**Consultation Response from KC,
Lead Local Flood Authority**

2023/91441 31, Chapel Hill, Linthwaite, Huddersfield, HD7 5NJ

Change of use and alterations to former church (B8-storage) to 9 residential units (C3) and formation of car park (Listed Building within a Conservation Area)

Date Responded: 16/06/2023.

**SECTION A-A THROUGH RAMP AND PARKING DECK**

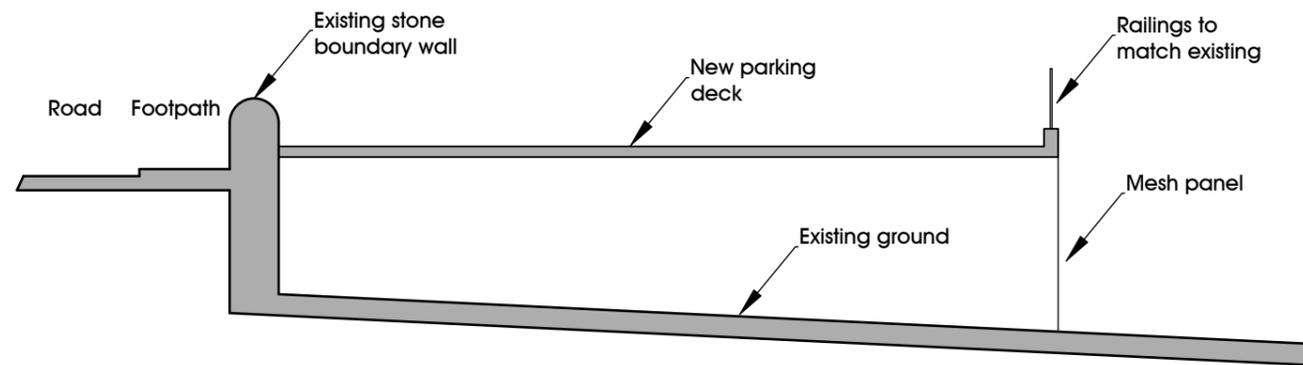
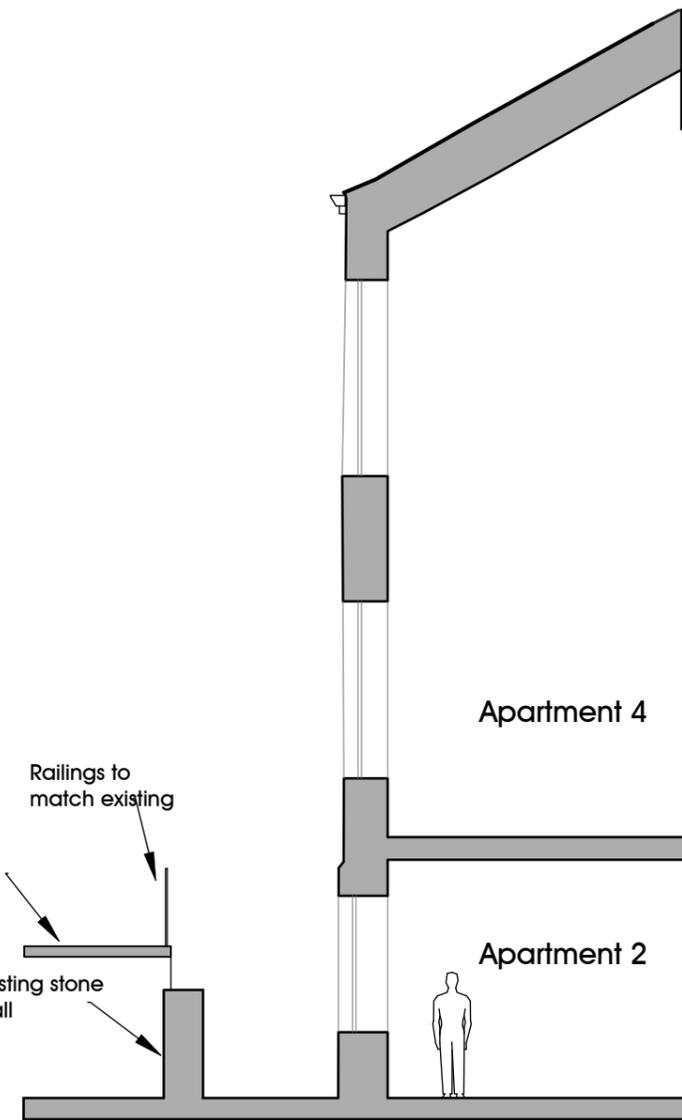
The proposed car park is located over a culvert carrying a Main River – the EA must be consulted for their comments on the proposal including easement requirements and methods of protecting the culvert during construction activities.

The organisation with the responsibility for the long term maintenance of the proposed permeable paving to the new car park should be identified.
